From: [Adam Osbekoff](#)
To: [Jeremiah Cromie](#)
Subject: RE: SE-22-00053 KC Flood Control Zone District - Notice of Application
Date: Thursday, June 2, 2022 3:35:19 PM

RE: SE-22-00053 KC Flood Control Zone District
I-90 Exit 74, West Nelson Siding Road.

SUBJECT: SE-22-00053 KC Flood Control Zone District

Federal Aid No.	
C.R.P. No.	
Plan and Profile	
PP-02	02 / 03

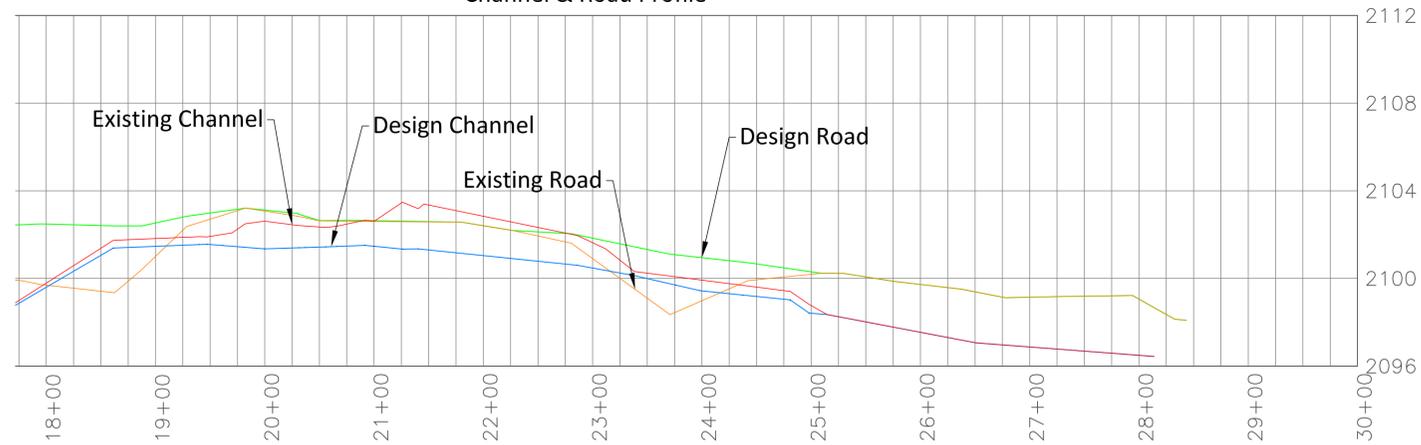
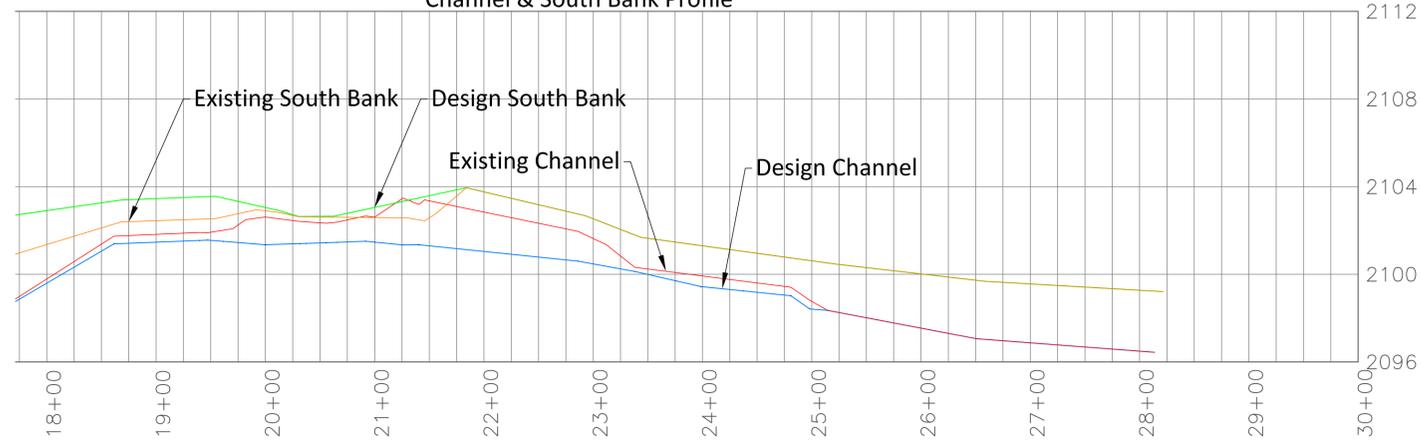
I attach an elevation profile (KittitasCounty_DraftPlans.pdf) that we received from Kittitas County a couple years ago, after we met with County engineers at this site. My concern is that the existing (unpermitted) adjacent road is consistently at a higher elevation than the proposed drainage ditch, which will make most of the work by Kittitas County a complete waste of time. Flood waters cannot reach the proposed improvements due to the impervious surface labelled "Existing Road" on attached document.

I request details of the County plan, showing how flood waters can ever even reach the proposed improvements. Most likely that would require installation of culverts under the "Existing Road" which crosses State Park property.

I'd like to add an update, as the "Existing Road" referenced in my earlier comments, was just resurfaced with fresh gravel, pictures attached from today. This flood water barrier is now a few inches higher, and further compacted as an unpermitted impervious surface, which worsens the problem I described in my comments.
